DFT PR-2024-010446

SI-2024-00774

RESPONSE TO: Code Enforcement Comments

Drawing file: Approved Plans / PR-2024-010446_SI-2024-00774_Site-Plan_Approved_5-14-25_Signed.pdf

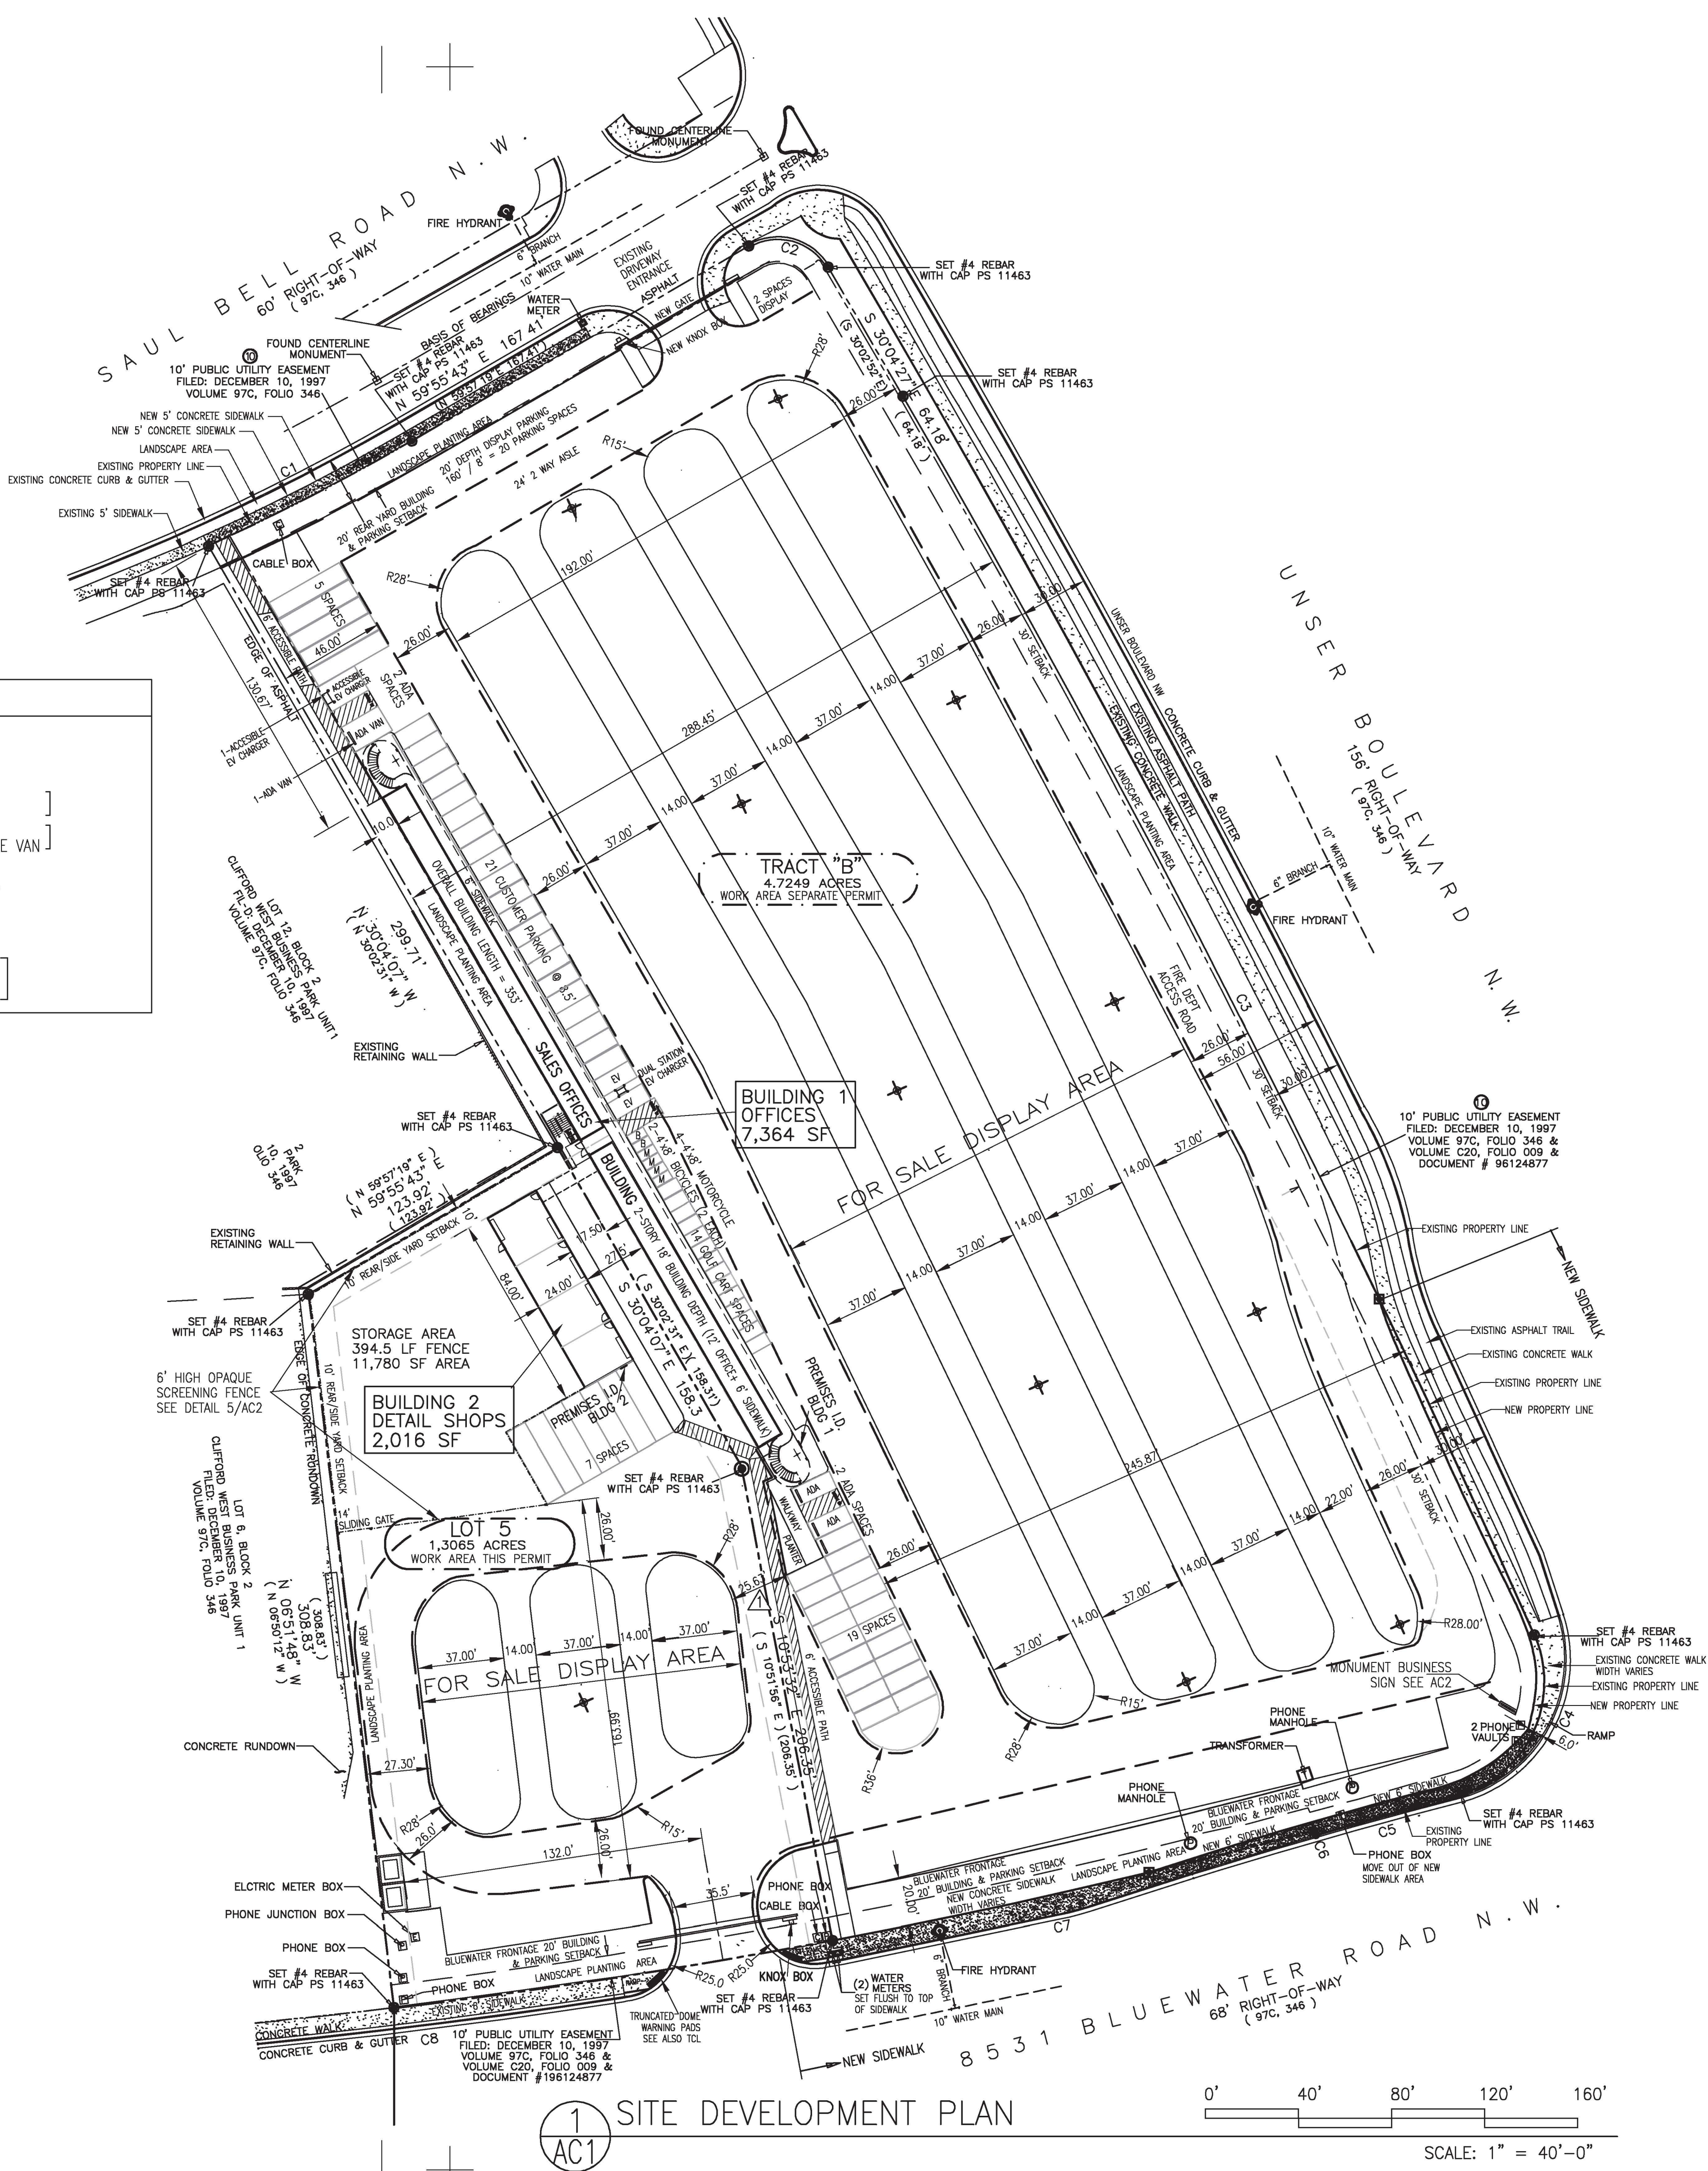
- **With a Bluewater address, the Site Plan, measurements, and Landscaping Plan will need to reflect that as the front lot line.**
 - The property address has been assigned as 8531 Bluewater Rd NW. This establishes the Front Line location on the south edge of Lot 5 and Tract B and is **reflected on Site Plan**

Location-addressing was confirmed on Bluewater. However, per the IDO, the address determines a corner lot’s front line. With a Bluewater address, the Site Plan, measurements, and Landscaping Plan will need to reflect that as the front lot line.

Currently it appears that Unser was used as the “Front”. **Please clarify.**

The Site Plan needs to include measurements for setbacks.

ADDITIONAL RESPONSE: As shown on the drawing Site Development Plan AC1, 8531 Bluewater Road SW abuts the southern property lines of both Lot 5 and Tract B. These property lines are thus designated as the Front Lot Line of this development. All other setback requirements are applied to the other property

the standard 10’ side or rear setback is not to be applied. For this project, all three street classifications are applicable. Setbacks are compliant as shown on the Site Plan Sheet AC1

A6

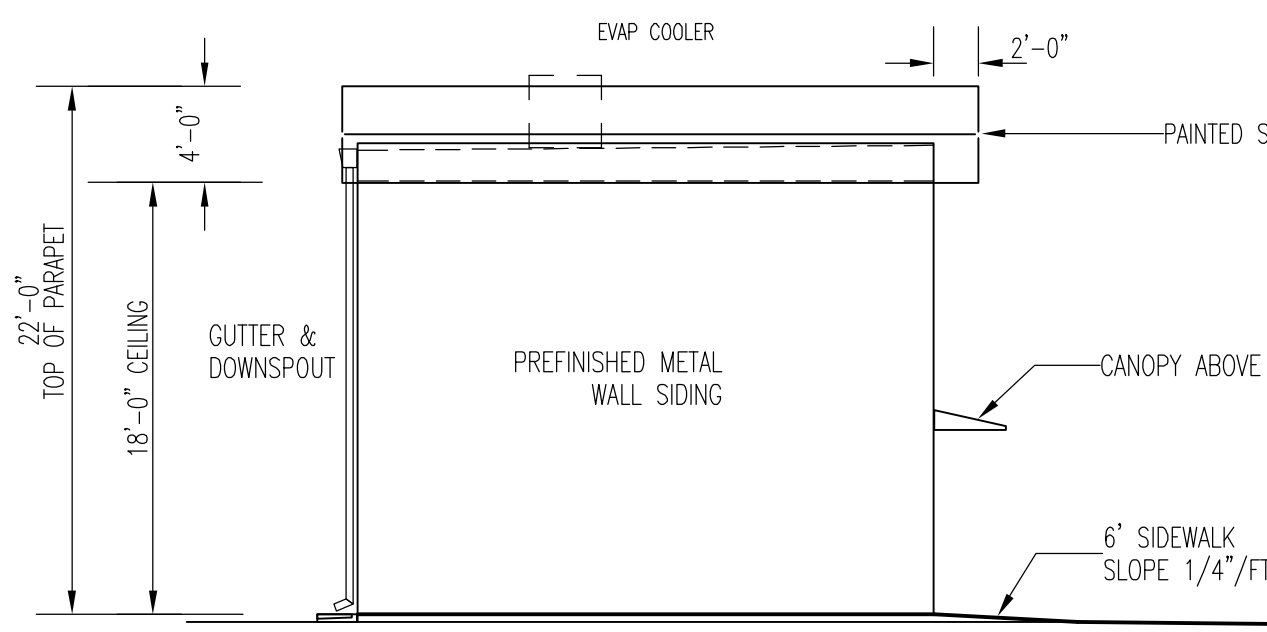
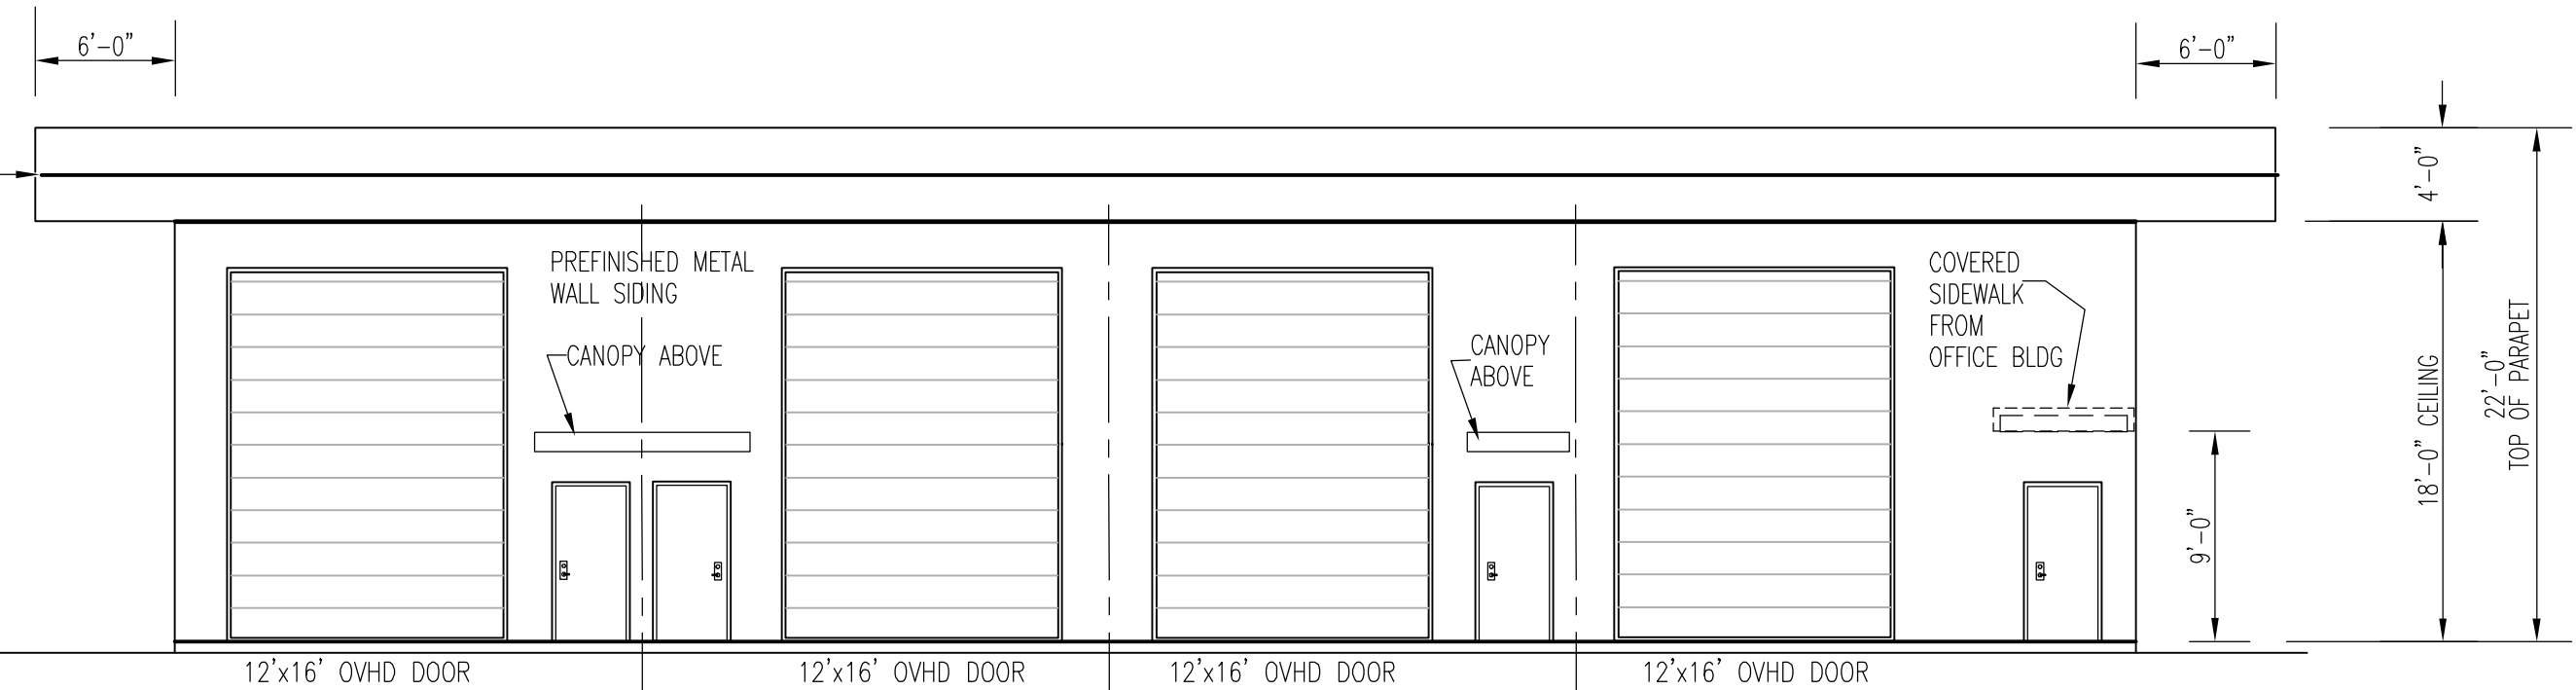
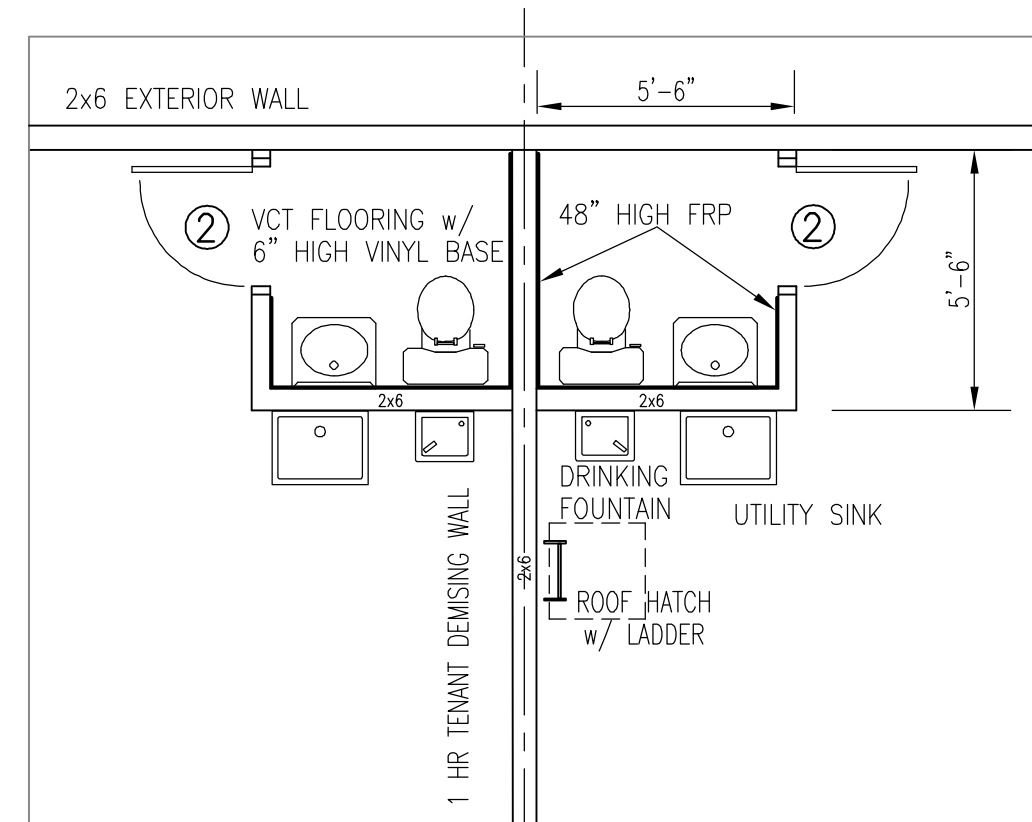
- **Elevation pages need to include measurements, dimensions, and information regarding screening. Provide detail to demonstrate and explain compliance with all sections within 5-11-E and 5-11-E-2.**

Include detail regarding how the façade and colors will meet the Clifford plan design requirements.

The CWMP Section **BUILDING REGULATIONS** details various means and measures to be employed in the façade design of buildings. These definitions and the IDO requirements are similar enough that one reflects the other. Both the CWMP and the IDO concerns are addressed as described below. The Building Elevations are shown on Sheet A1 Office Building and Sheet A6 Shops Secondary Building.

See new Sheets A1 and A6 for elevation information. Concept designs have been added {pgs 3&4) for visual clarification.
